DEXUS ESTATE INDUSTRIAL PARK PROJECT (MP 08_0259) MODIFICATION (MOD 2) – SUPERLOT C AMENDMENT – ADDITIONAL INFORMATION

I refer to the above application and Holroyd Council's (Council's) submission on the application dated 25 January 2012. A response to the issues raised in Council's letter is presented below. It is noted that the RMS also made a submission on the proposal (dated 25 January 2012), but did not raise any specific issues in relation to the proposal.

BASALT ROAD - PROPOSED BREAKS TO MEDIUM STRIP

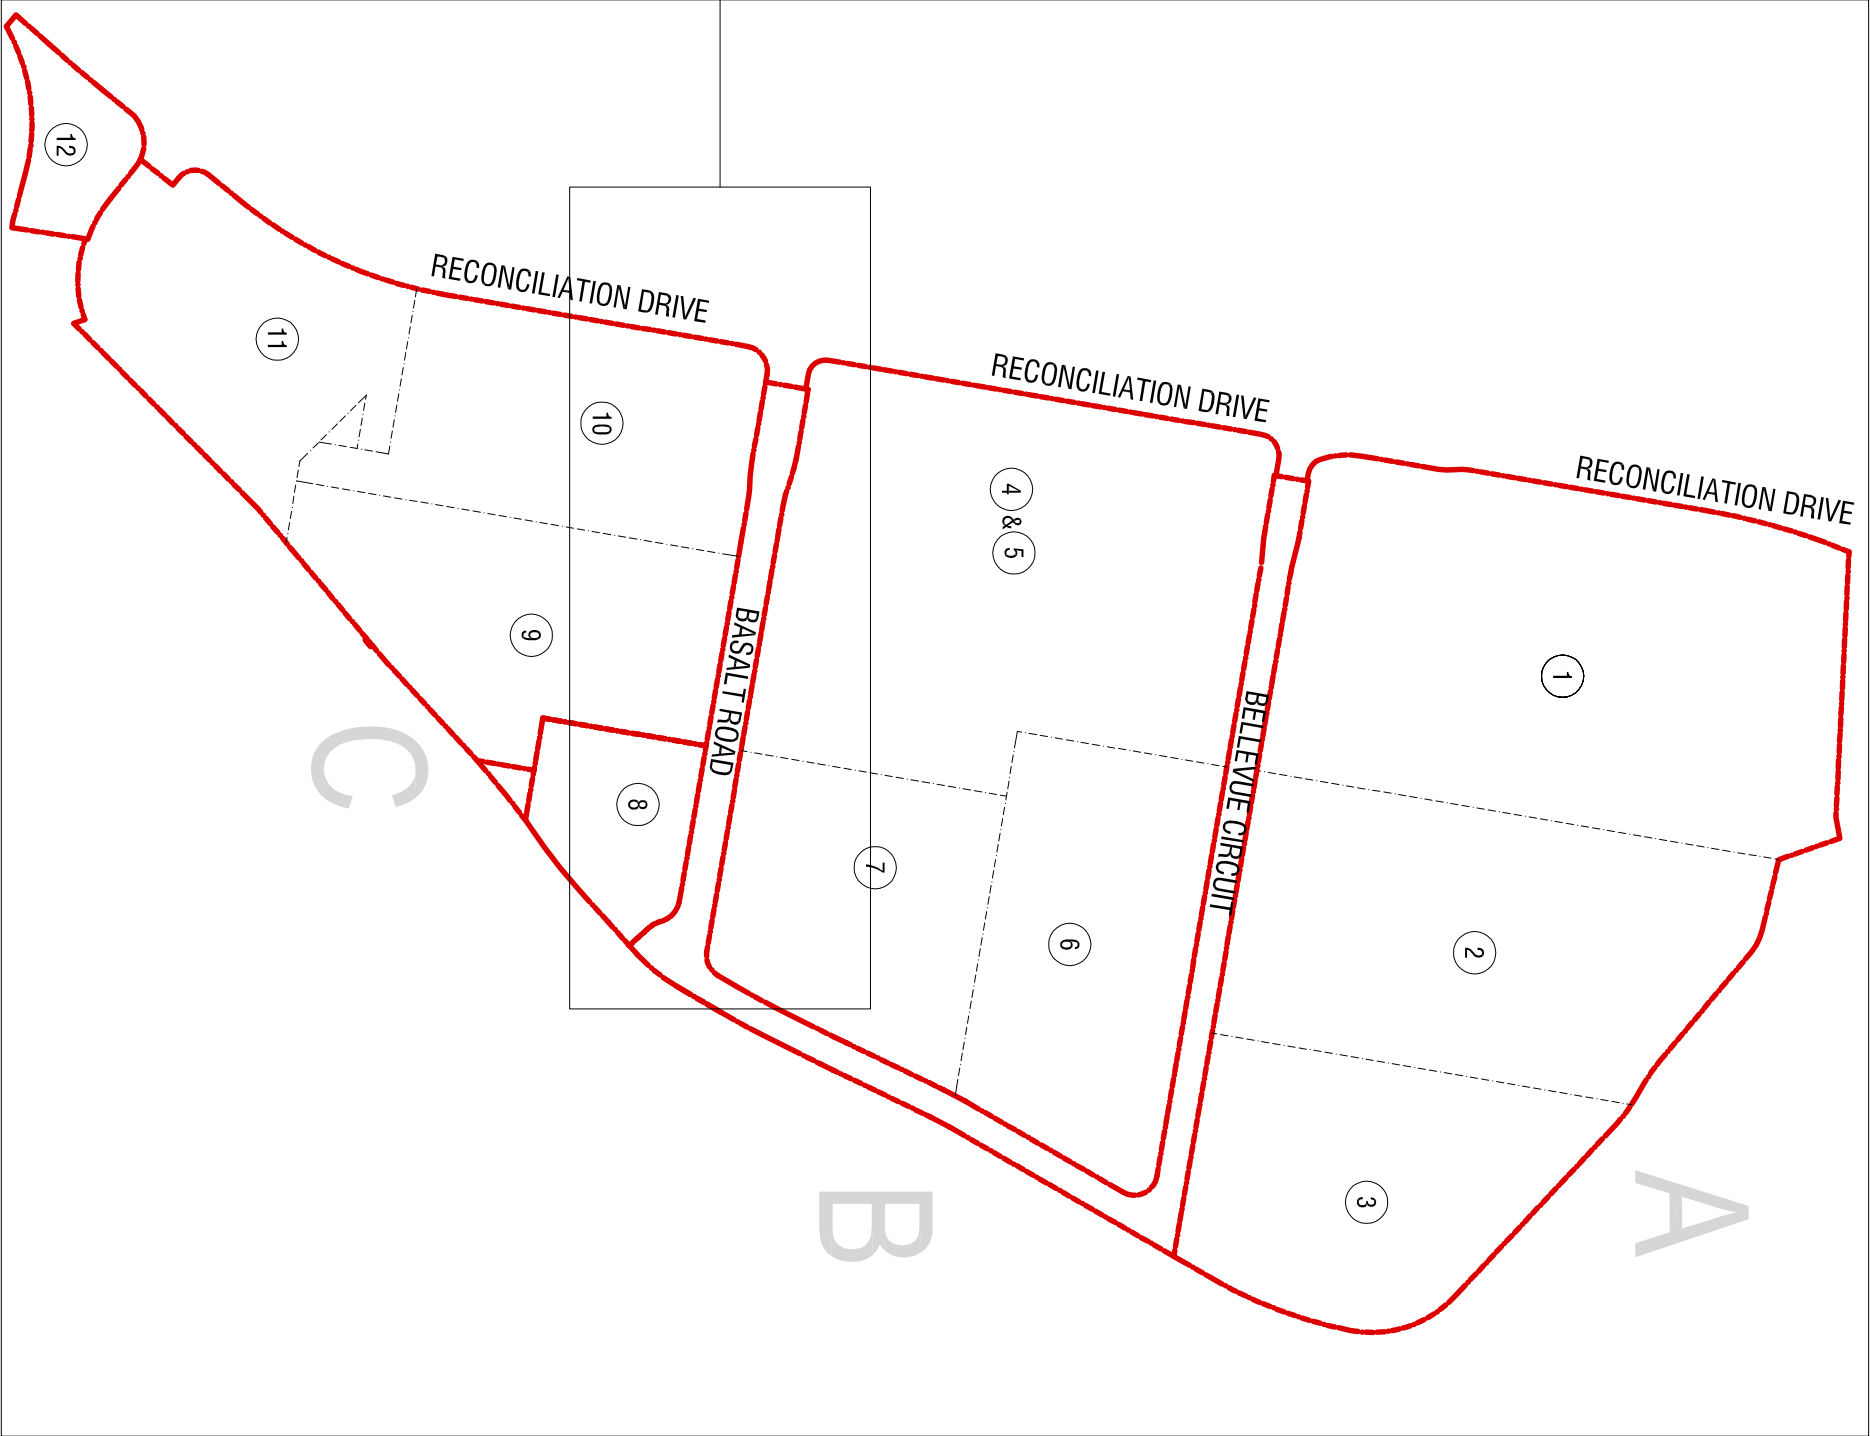
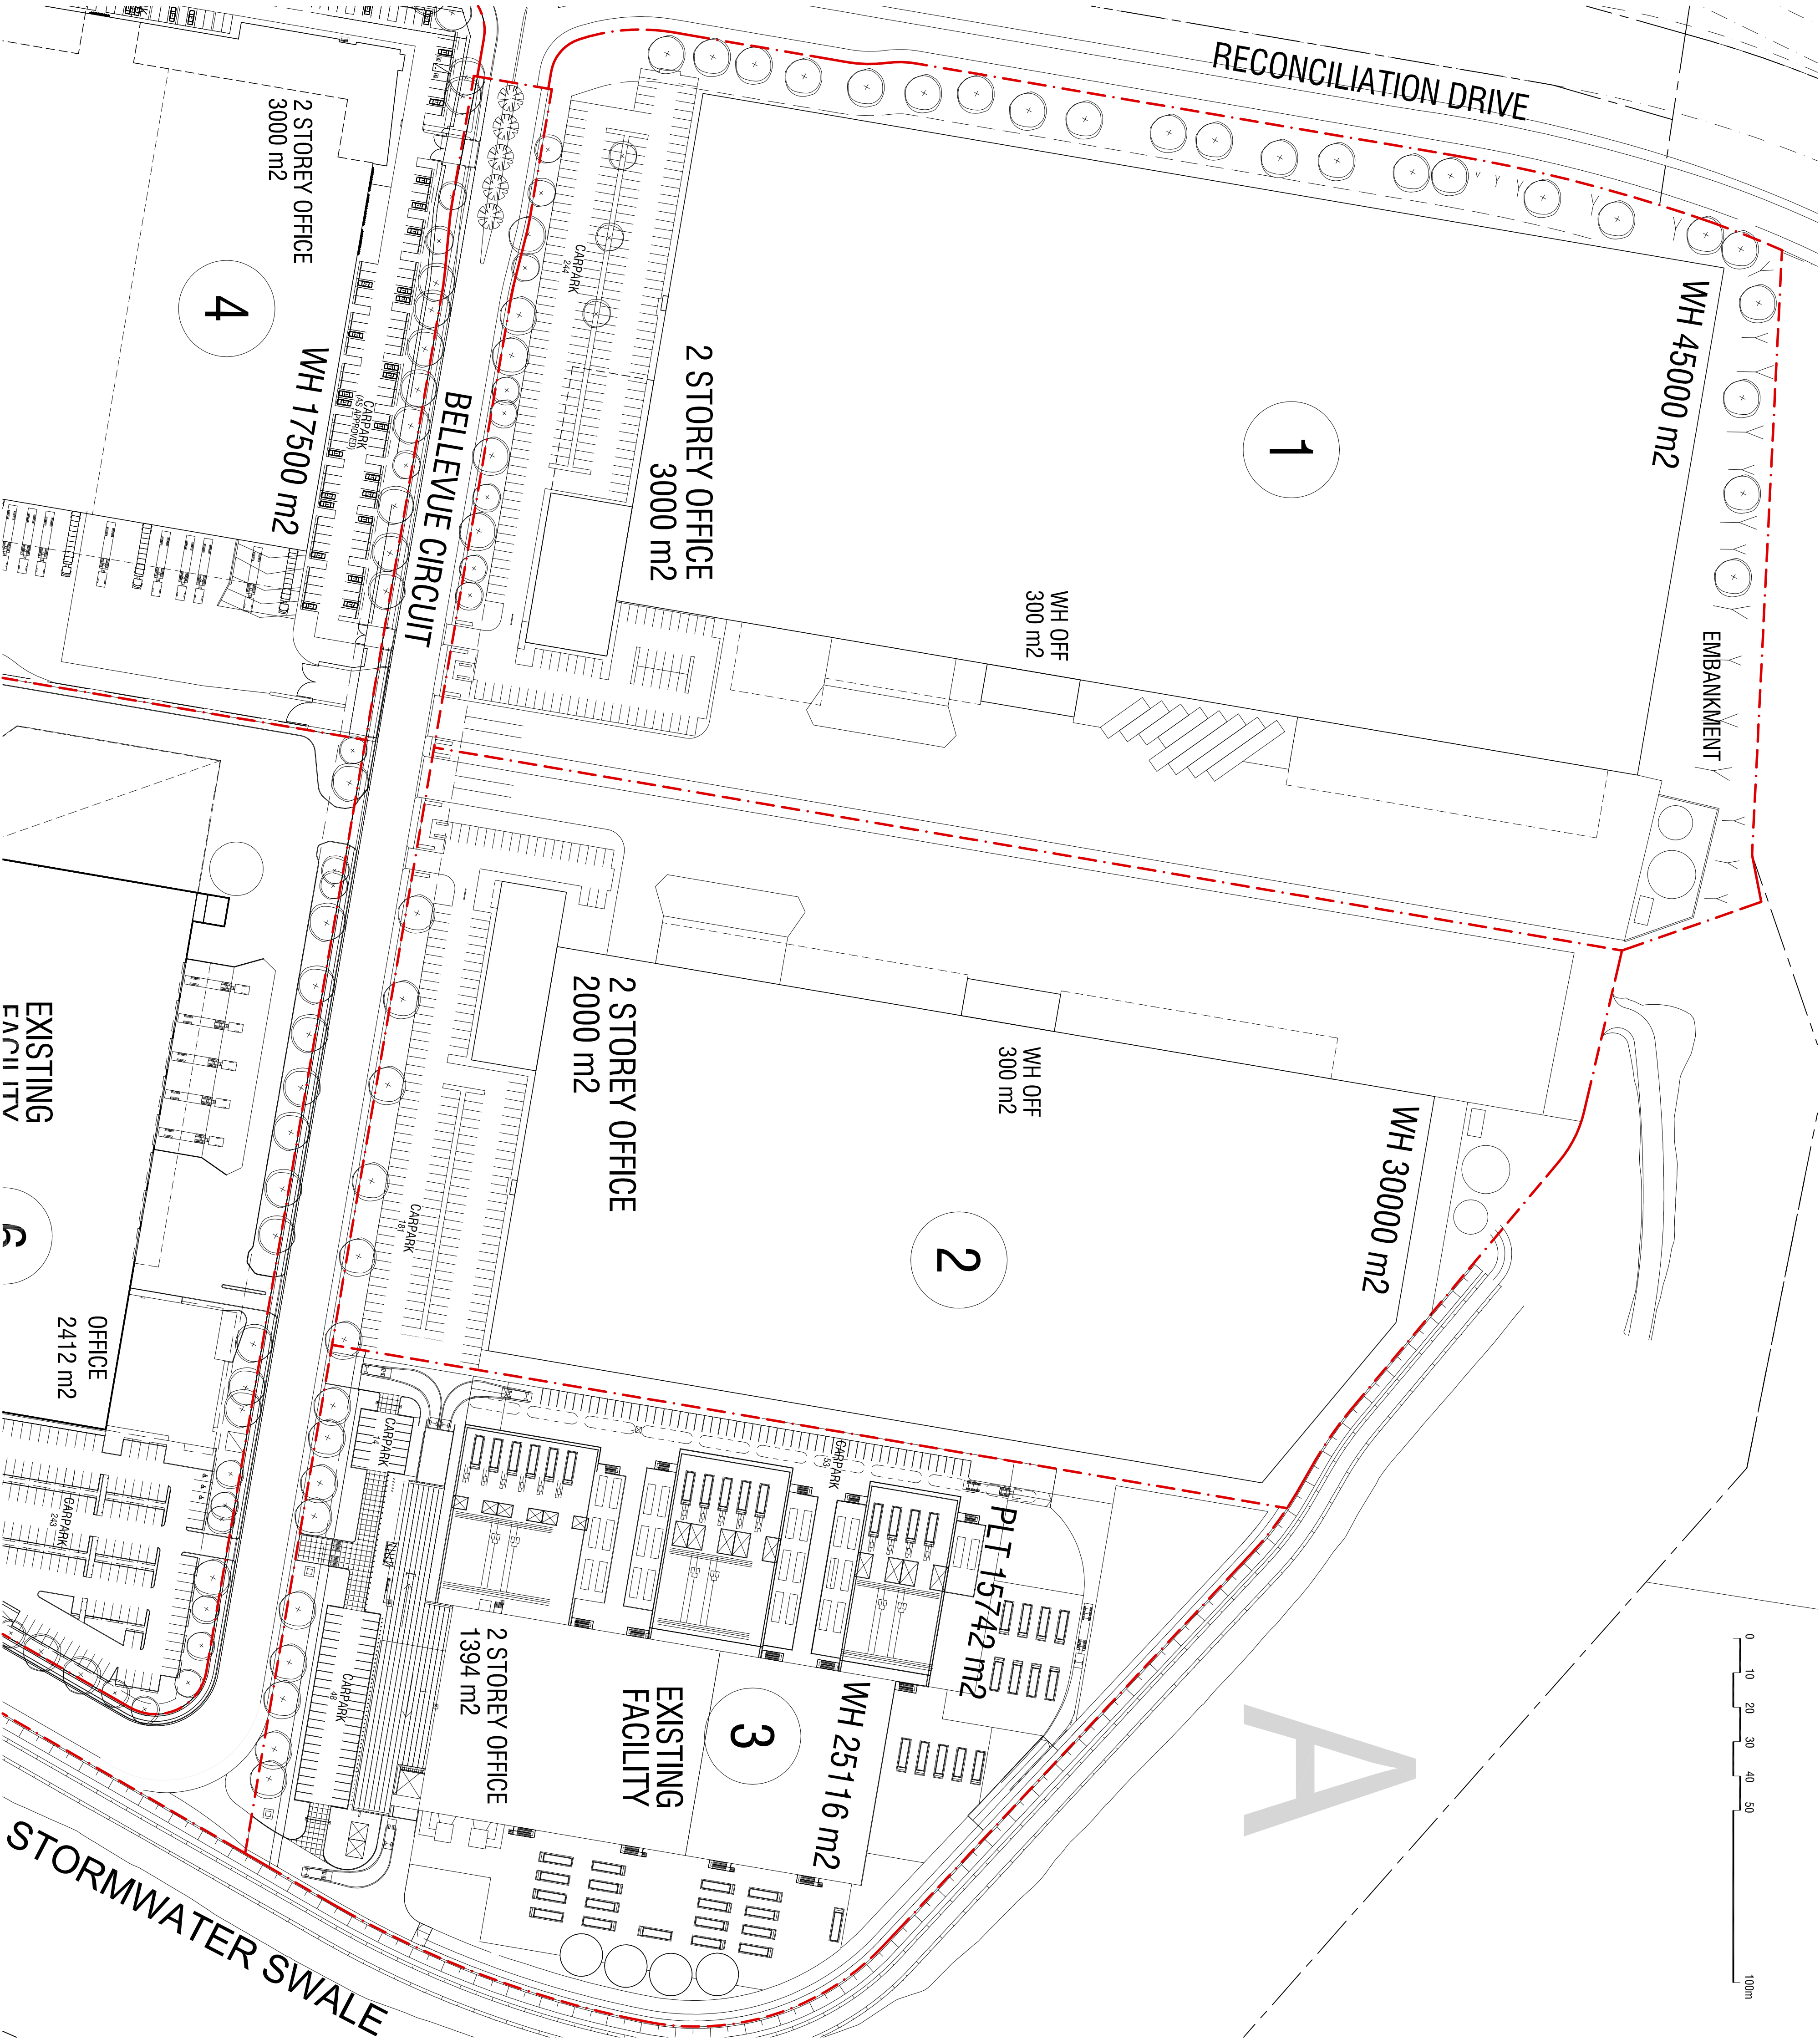
To address this issue, DEXUS has amended the breaks in the median in Basalt Road by limiting the number of breaks to two, and strategically locating the breaks to avoid traffic conflicts. The breaks as originally proposed in the modification application (MOD 2) are shown on **Figure 3**, and the amended breaks are shown on **Figure 4**. The revised architectural plans are attached in **Appendix B**.

b) The central median on Basalt Road is proposed to have a break to allow right turn movements in and out of Lot 9, Lot 10 & Lot 11 loading dock driveway. In addition the loading dock driveway is proposed to be directly opposite the loading dock driveway for Lot 5 forming an intersection. This will cause a major right turn conflict point on Basalt Road. The traffic report used SIDRA Intersection to analyse the intersection. SIDRA is not suitable for modeling an intersection which is solely used for heavy vehicles. It is also noted that SIDRA does not model road safety impacts of intersections.

c) The central median on Basalt Road is proposed to have a break to allow right turn movements in and out of Lot 9 car park driveway. In addition, the driveway will be opposite the car park driveway for Lot 5. This will cause another right turn conflict point on Basalt Road.

As outlined above, DEXUS has amended the breaks in the median in Basalt Road by limiting the number of breaks to two. The proposed breaks in the median provide right turn access to/from the loading dock area of Lots 9, 10 and 11 (located on the southern side of Basalt Road) and to/from the loading dock area of Lot 5 (located on the northern side of the road).

The design of the access driveways to Lot 5 and 9 car parks in Basalt Road has been amended with the central median across these driveways maintained. As such, access to Lot 5 and 9 car parks would be restricted to left in and left out.
